EROSION AND STORMWATER QUALITY CONTROL PERMIT (ESQCP) EL PASO COUNTY APPLICATION AND PERMIT

EPC Project Number: **CDR248**

FALCON AREA WATER & WASTEWATER AUTHORITY
BAR X 1041
ADJACENT PROPERTY OWNERSHIP
OPTION 1

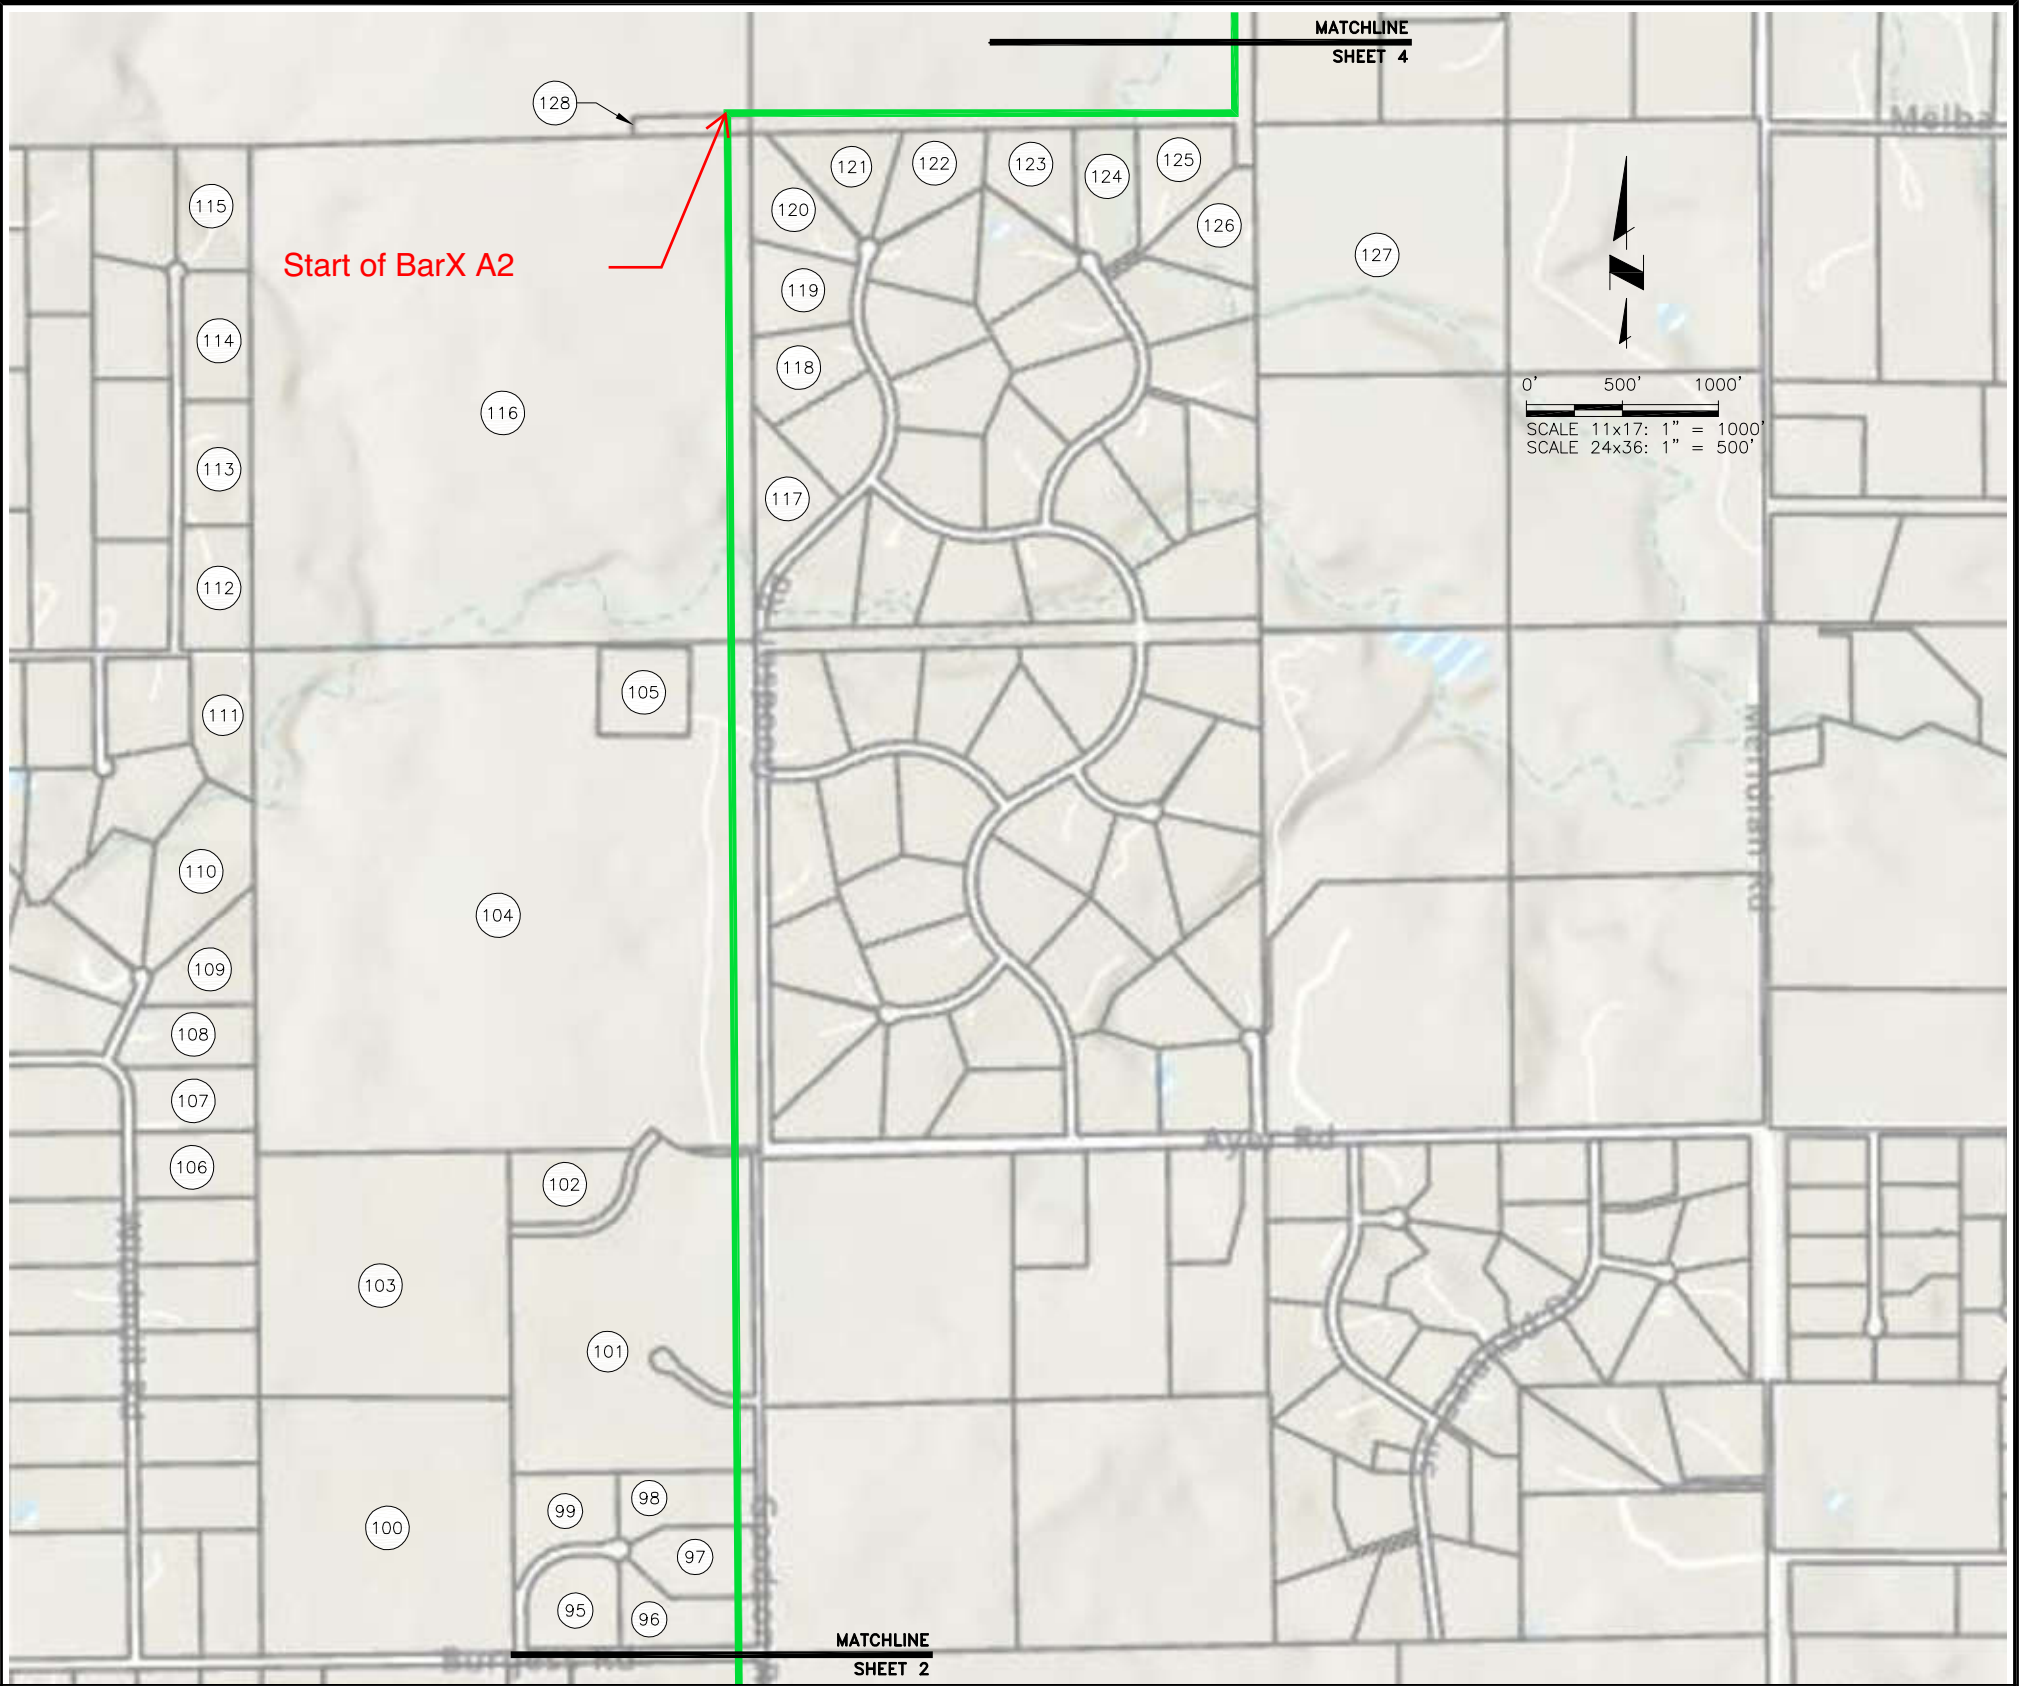
Clearly identify the limits of Bar X Segment 2. Make that section a different color and box all the parcels below that apply specifically to this project.
